Application for a non-material amendment following a grant of planning permission.
Town and Country Planning Act 1990

House:		Suffix:	
House name:	Badgers		
Street address:	Ham Manor Way		
Town/City:	ANGMERING		
Postcode:	BN16 4JQ

first floor side extensionm

first floor window added to South elevation

Issue	Details	Drawn	Check	Date
SCALE	AS SHOWN on A1			
DATE	31/08/17			
DRAWING NUMBER	17027/02R3

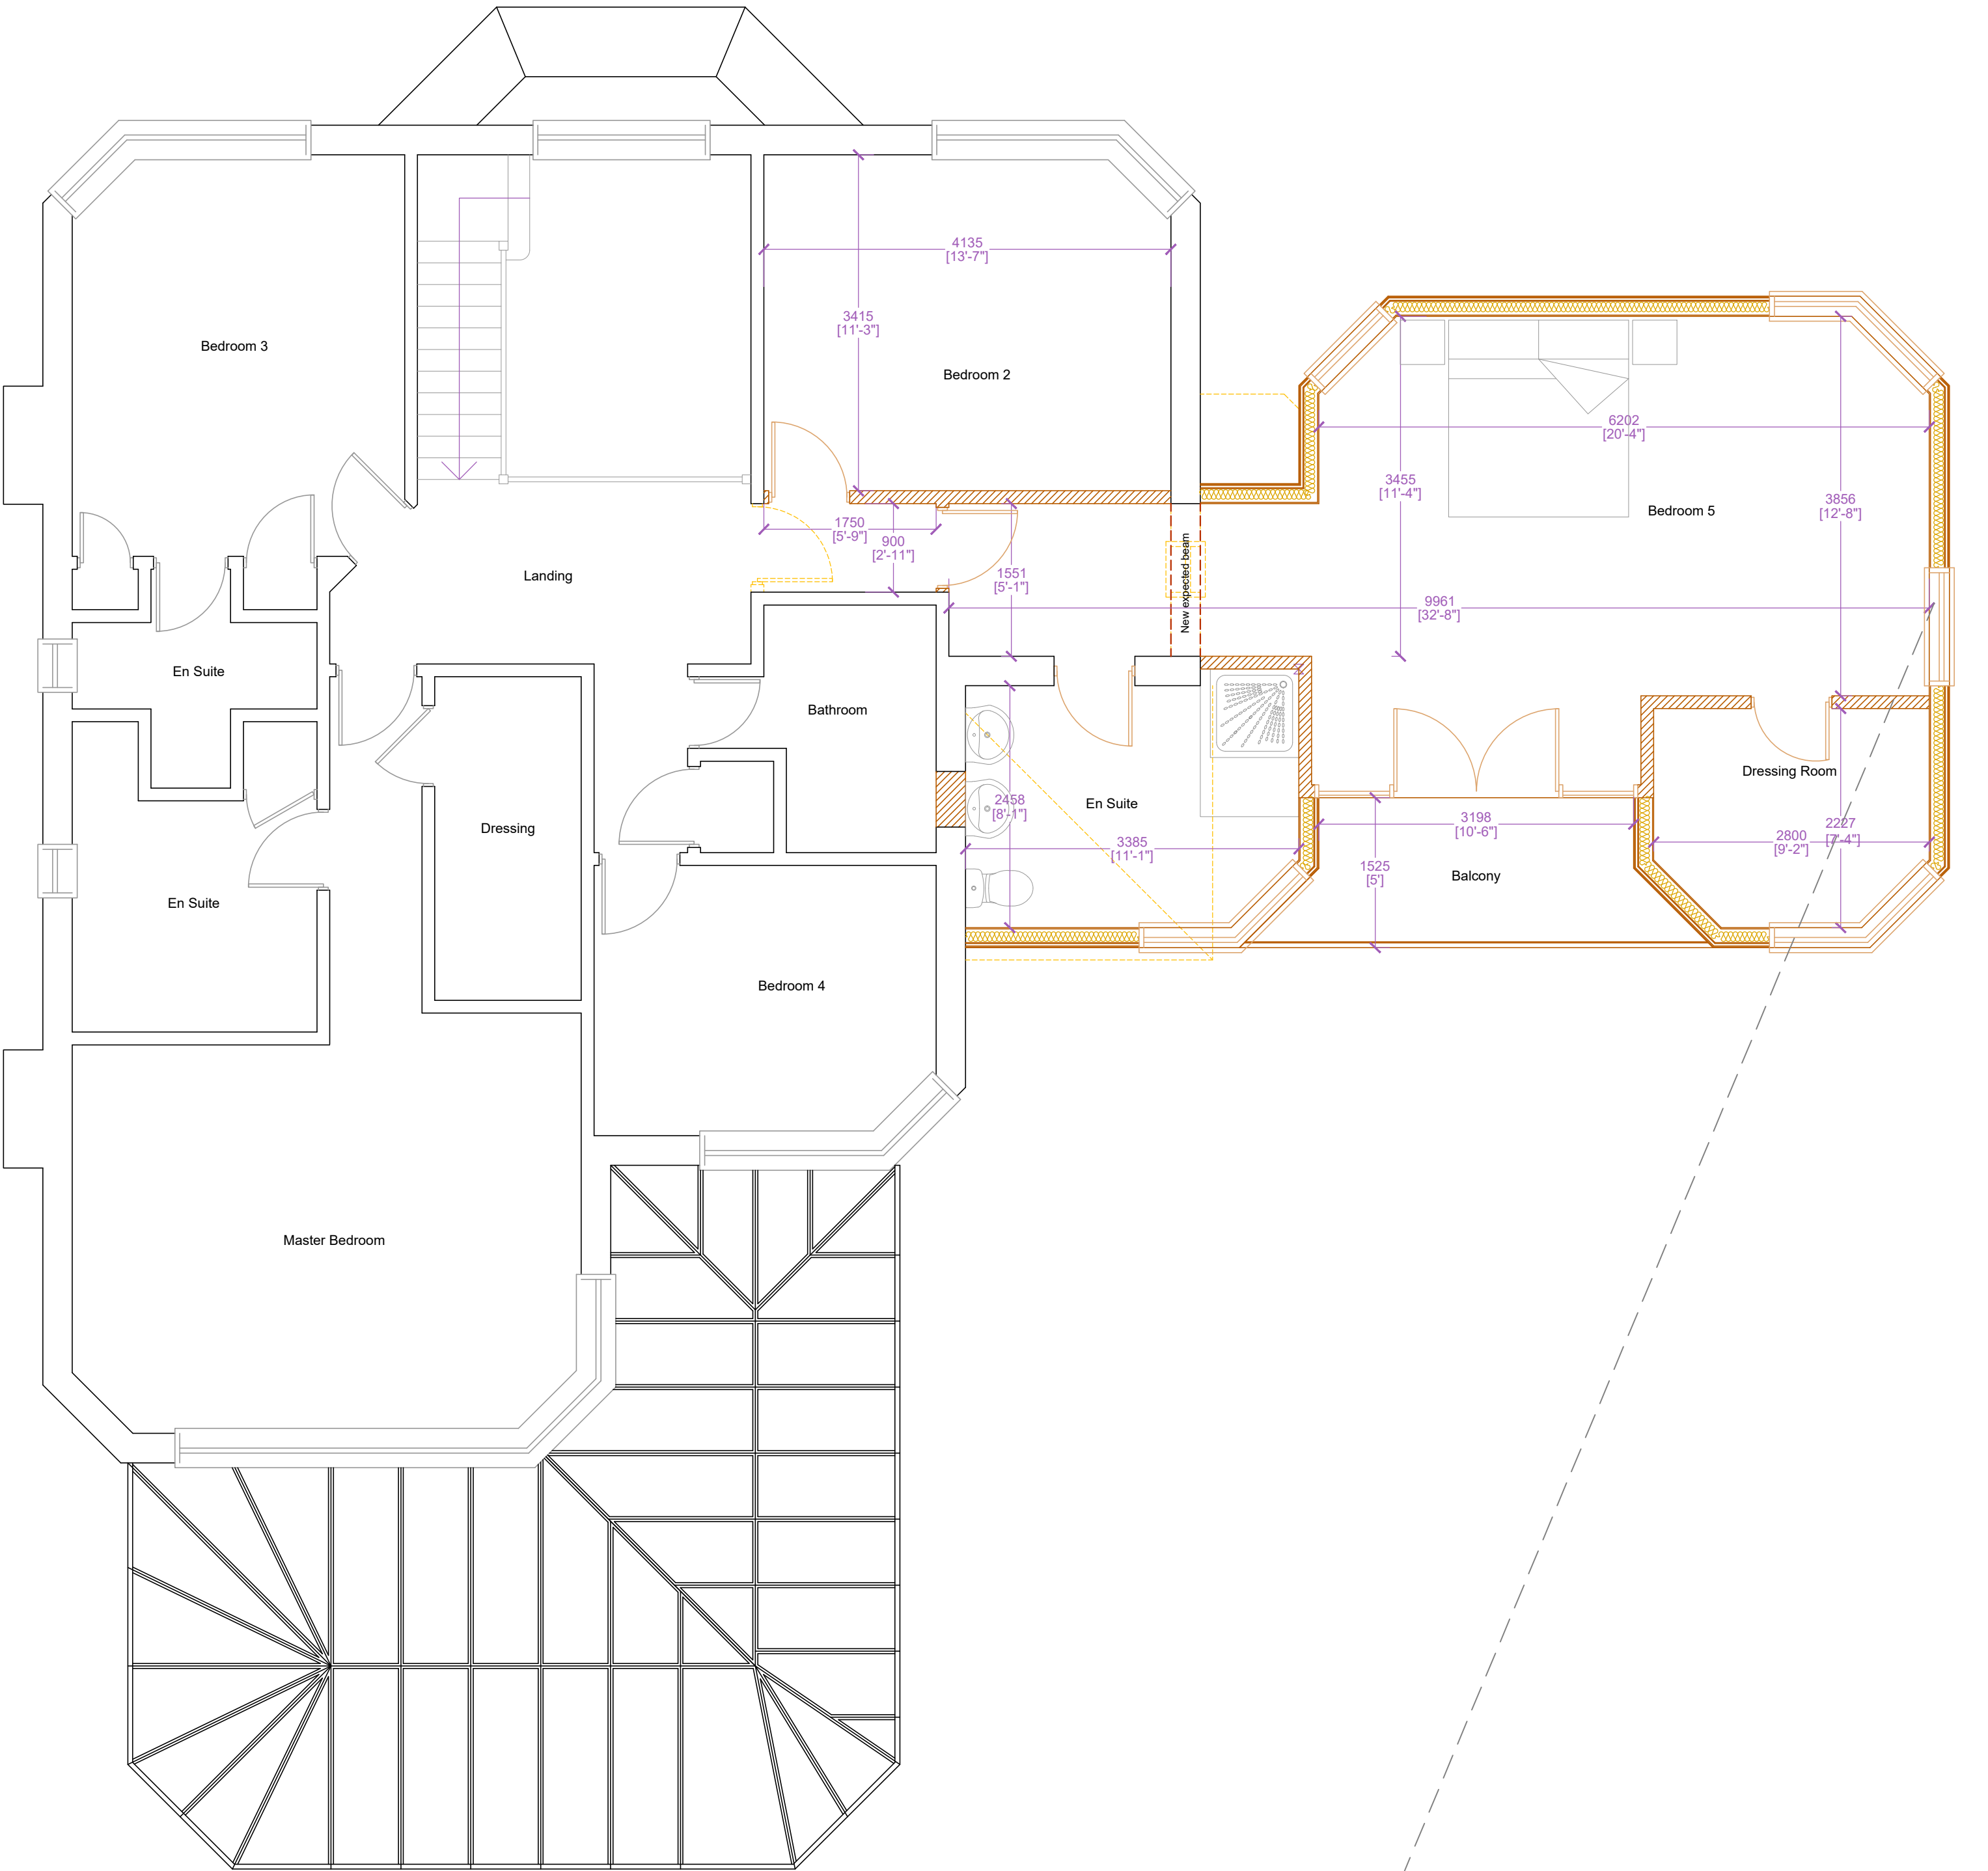
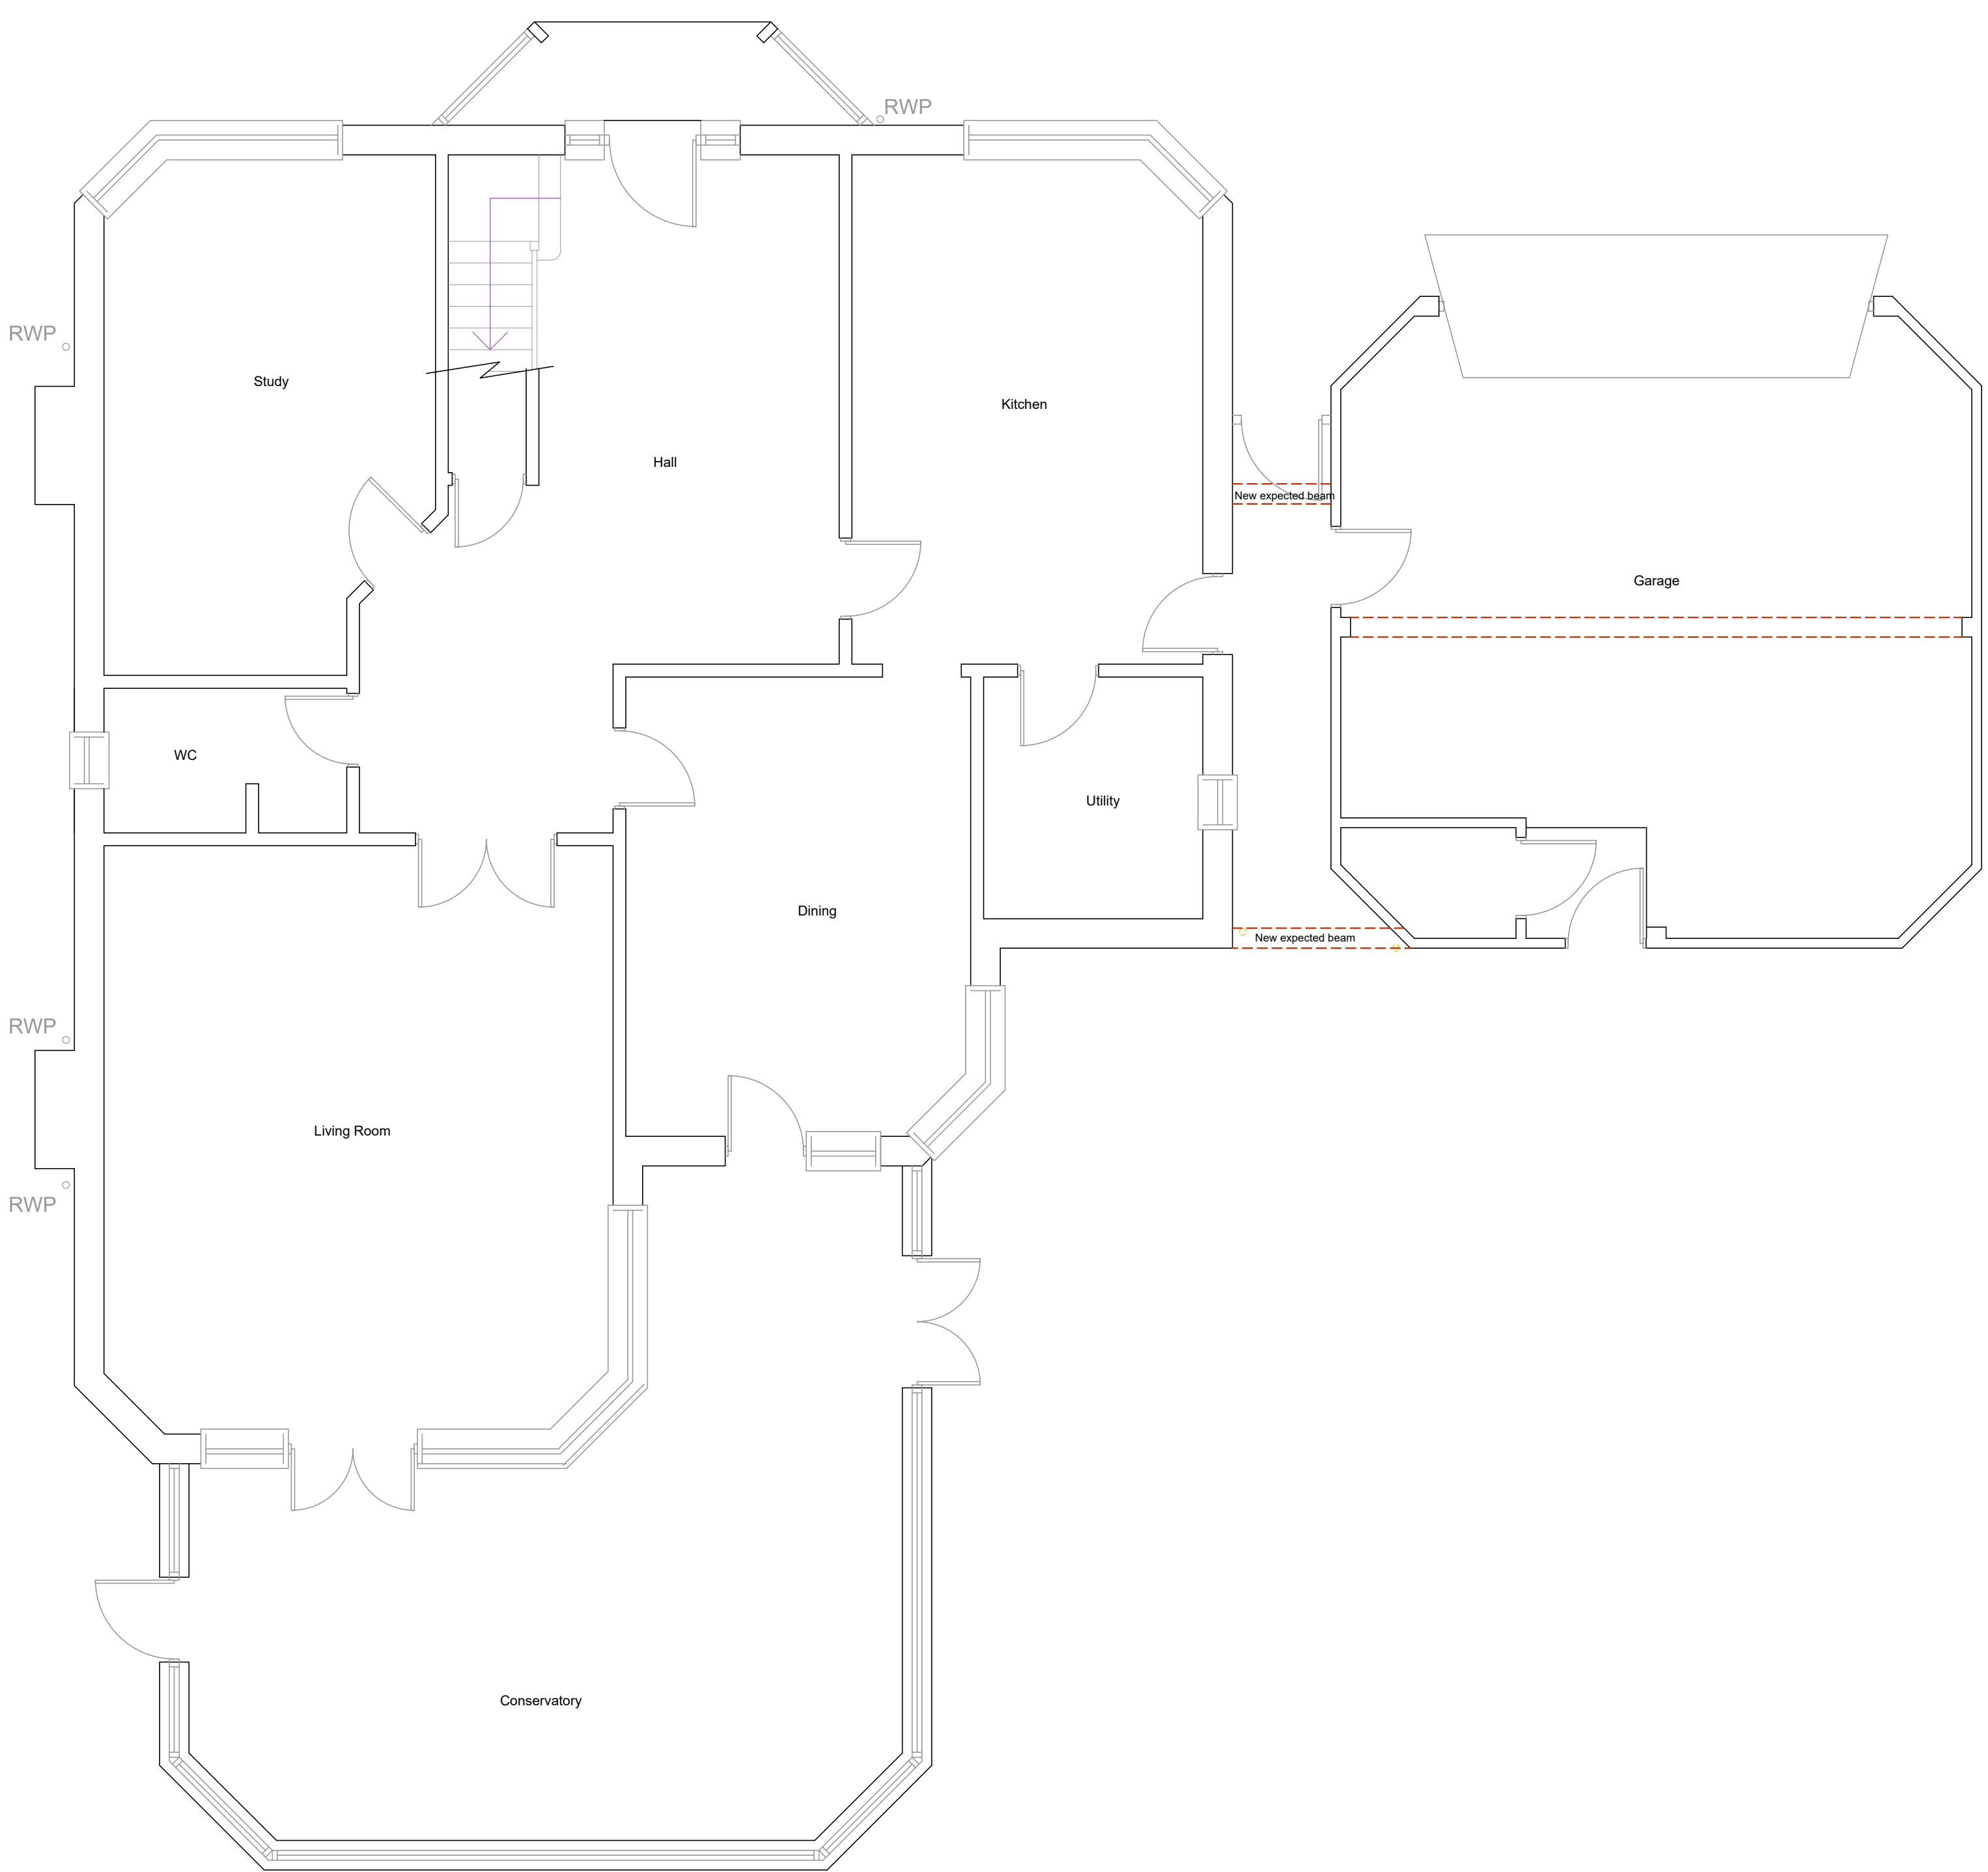
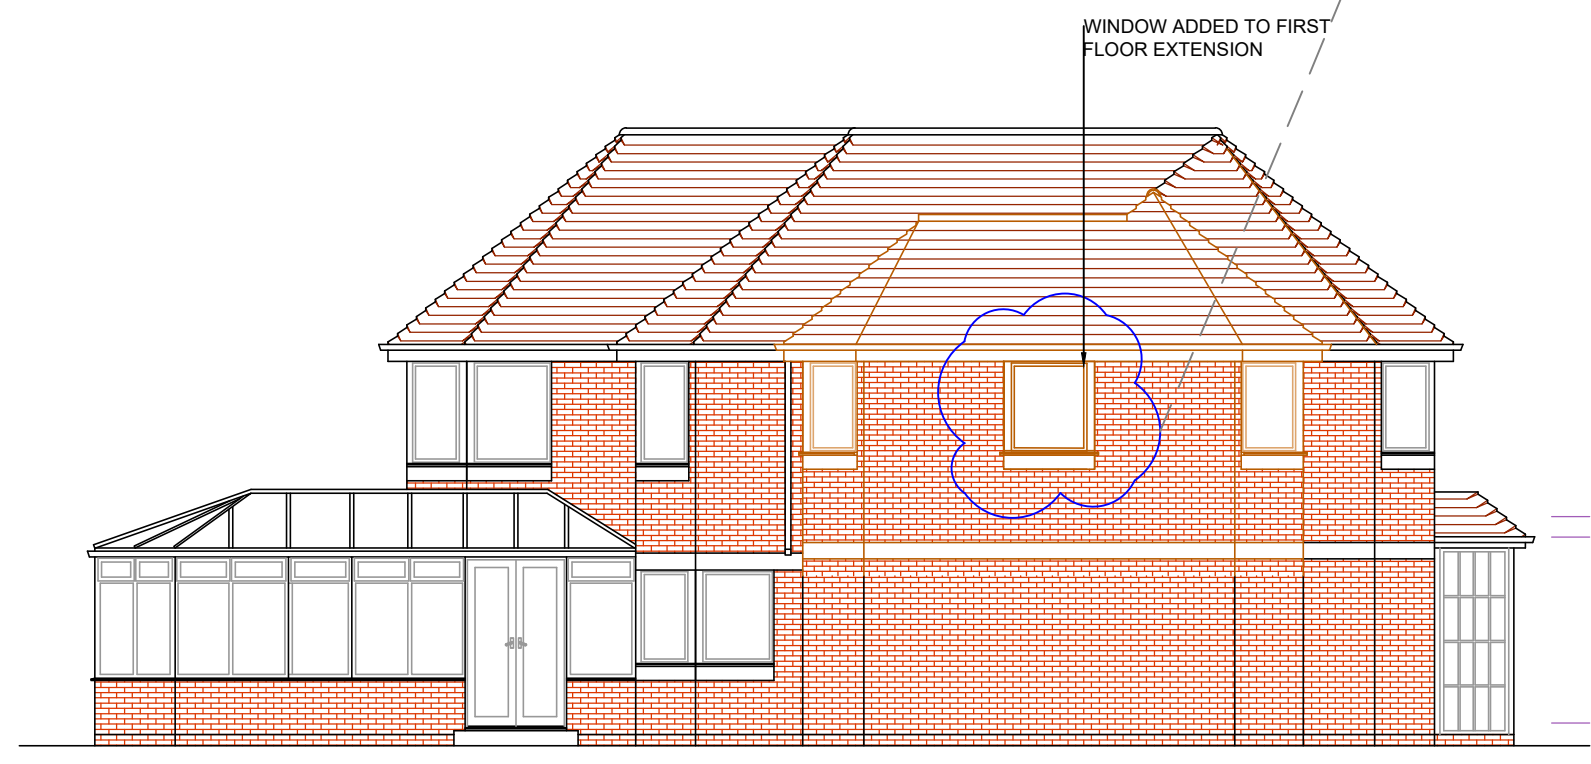
This plan was issued to Planning but not included in Application drawings. Client design change - required additional window

17027/02 R3
